**Consultation Response from KC,
Trees**
2020/93921 Huddersfield Grammar School, Luck Lane, Marsh, Huddersfield, HD1 4QX
Installation of temporary grasscrete staff car park (within the curtilage of a Listed Building)
Date Responded: 09/12/20
**Responding Officer: Nick
Goddard**
Responding Ref: TPO 03/79

Revision	Drawn	
Project	CB	
Staff Car Park	Date	Scale(s) @ A3
Huddersfield Grammar School, Luck Lane Huddersfield HD1 4QX	23.10.2020	1:250
Client	Status	
Cognita	Planning Issue	
Sheet Title	Project No.	Rev
Existing Site Plan	88:20	
	Dwg No.	
	8820_P01

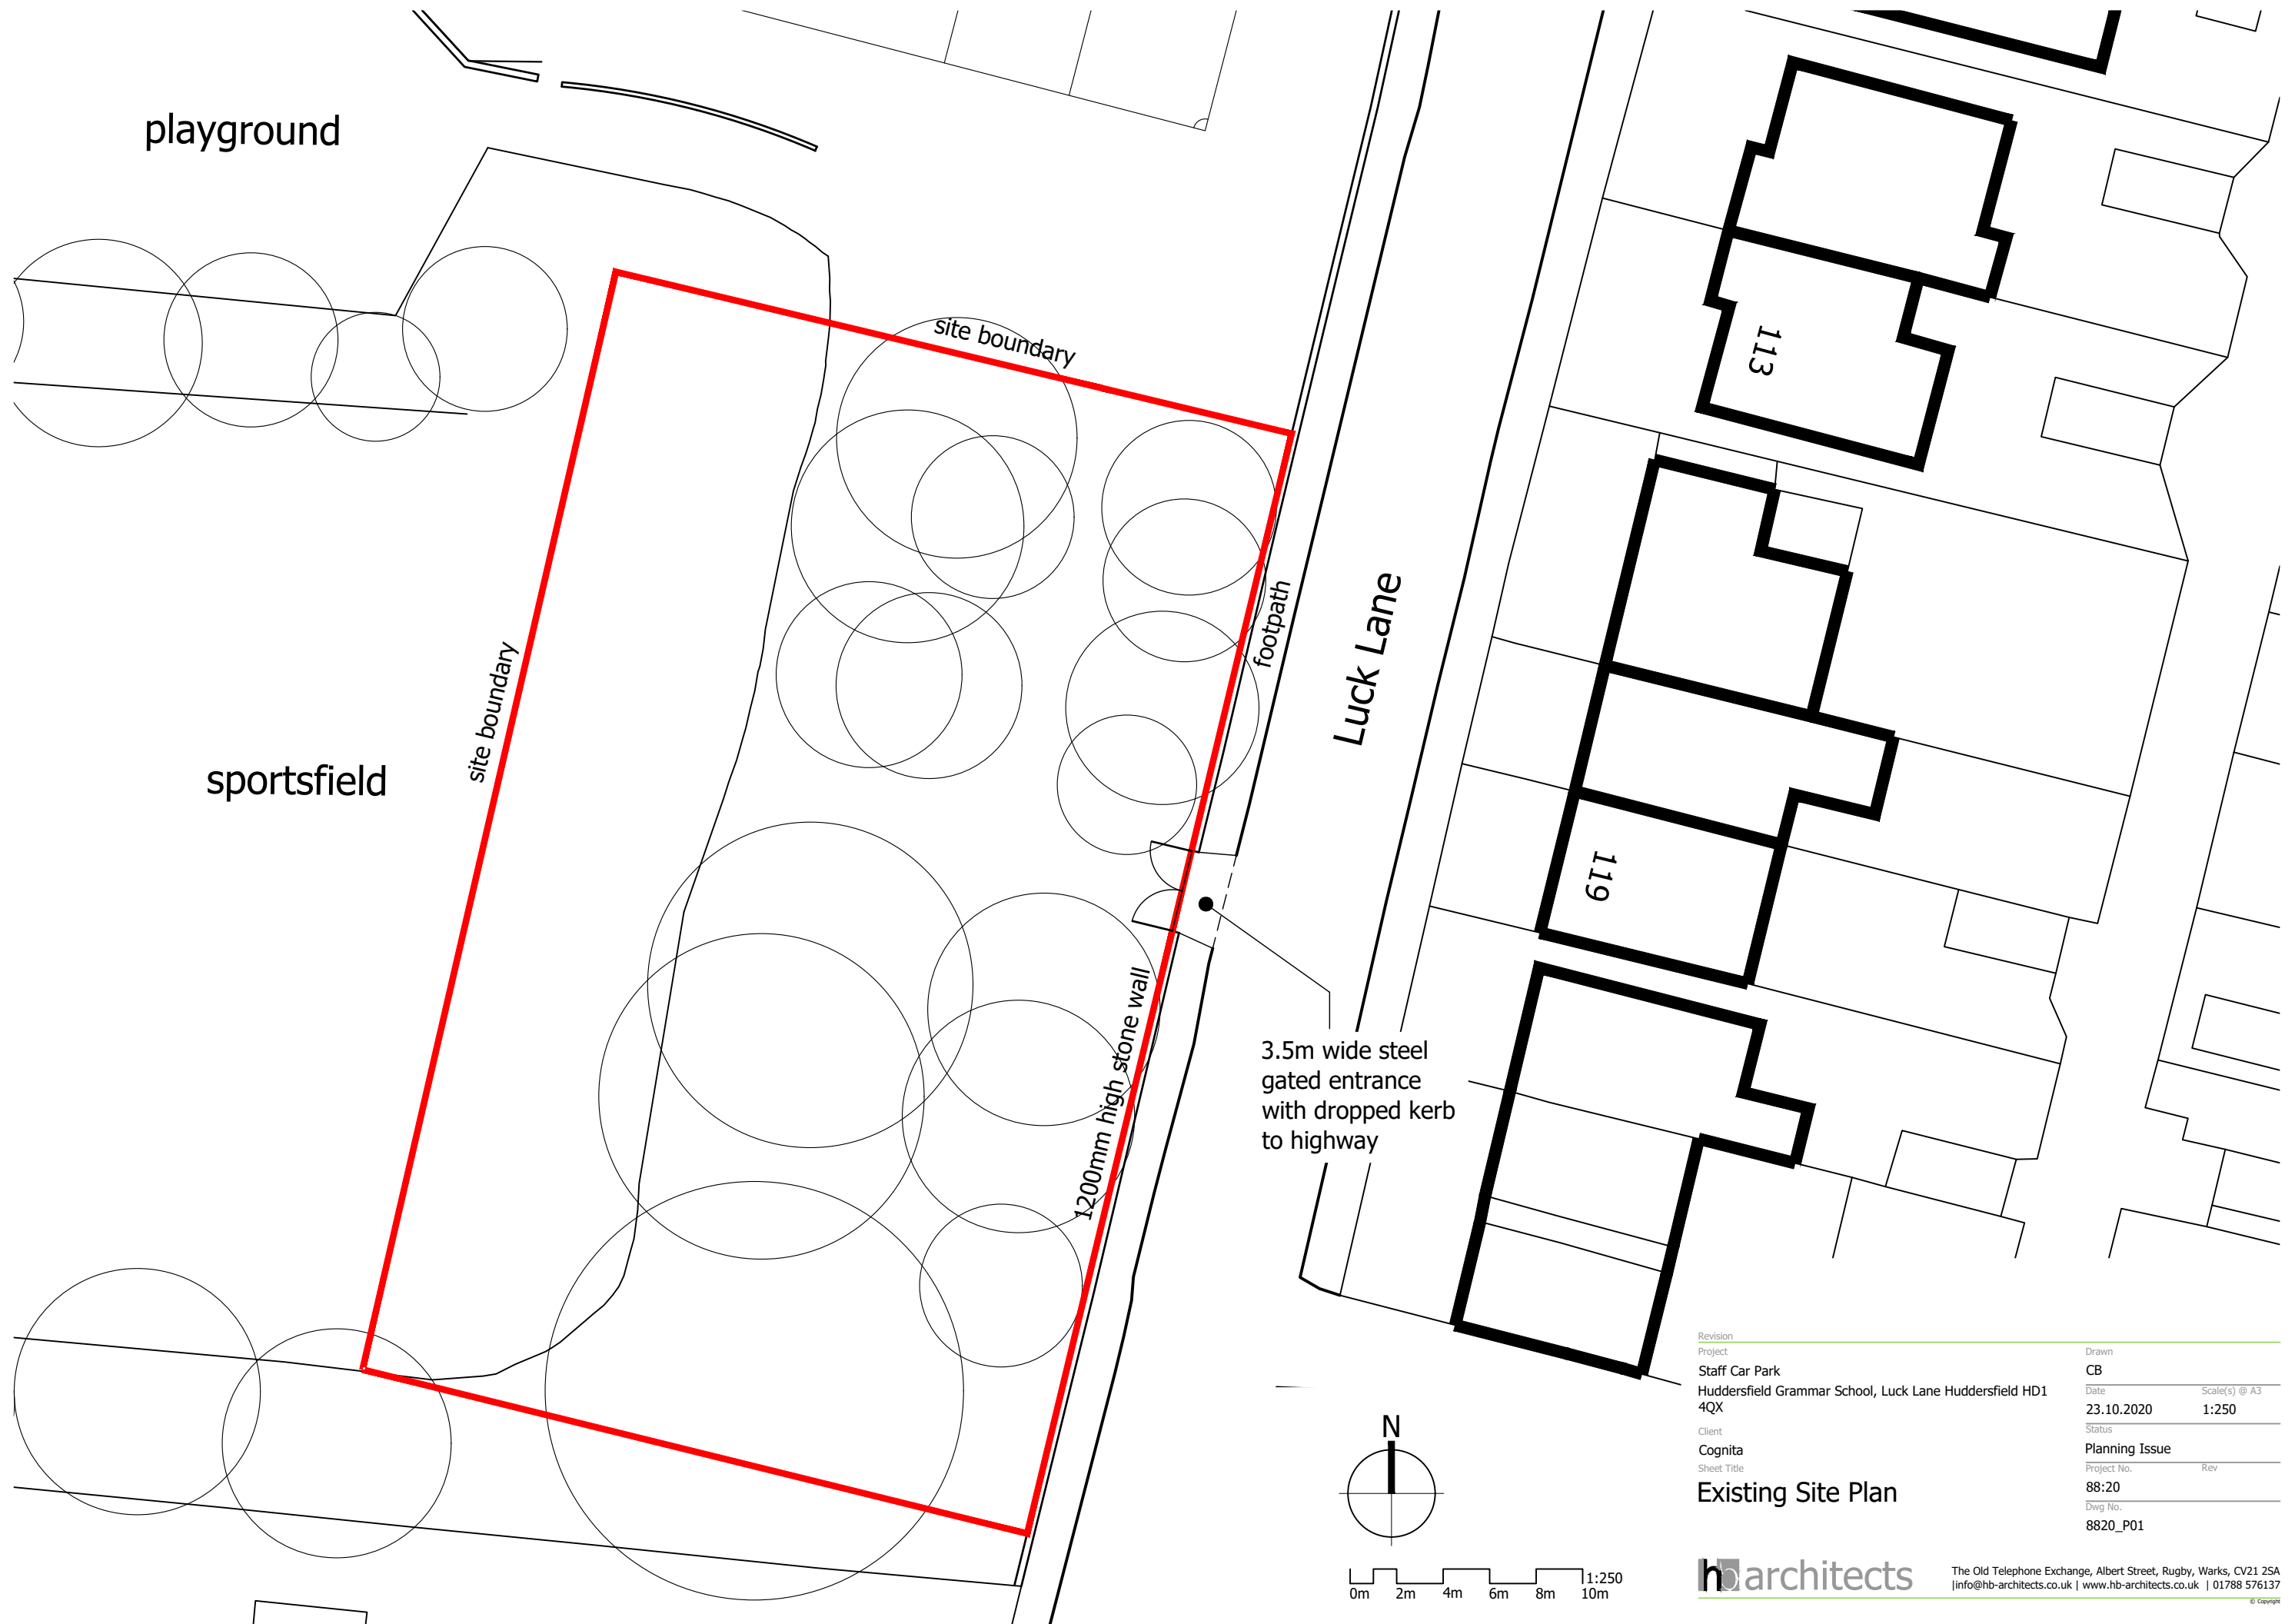
The application does not include any detailed tree survey or arboricultural impact assessment for these proposals. The site is almost entirely within a protected woodland under Tree Preservation Order 03/79. The woodland provides a significant contribution to public amenity and the character of the area. The protection of the health and longevity of the woodland needs to be a priority in the design of the proposals. With the right design and tree protection measures, it may be possible to achieve some level of parking in this area.

Having read the DAS, I understand that there are to be up to 20 cars a day using this access and parking in this area. The proposal is to use Grasscrete for the parking areas to ensure no adverse damage to the root systems of trees and that this parking is to be used until Summer 2021. I note there is much detail in the DAS about the history of the Grammar School and its listed status however no mention of the protected status of the woodland.

There appears to be a misunderstanding of how Grasscrete is installed but the manufacturer of Grasscrete describes, on its own website, that it should be laid over a sub-base and the usually this is after topsoil has been removed. I use of Grasscrete is likely to result in excavation or stripping of topsoil and compaction on the site from the laying of the sub-base and weight of concrete. The lack of detail about these proposals gives no assurance that the trees will not suffer long term harm by these proposals. In addition, Grasscrete is not generally used as a temporary measure because it is not easy to remove once laid.

I'm afraid, I fundamentally disagree with the proposed method of construction of this car park and the long term health and viability of this section of woodland would be put at risk by these proposals and therefore they do not meet with policies LP24i and LP33.
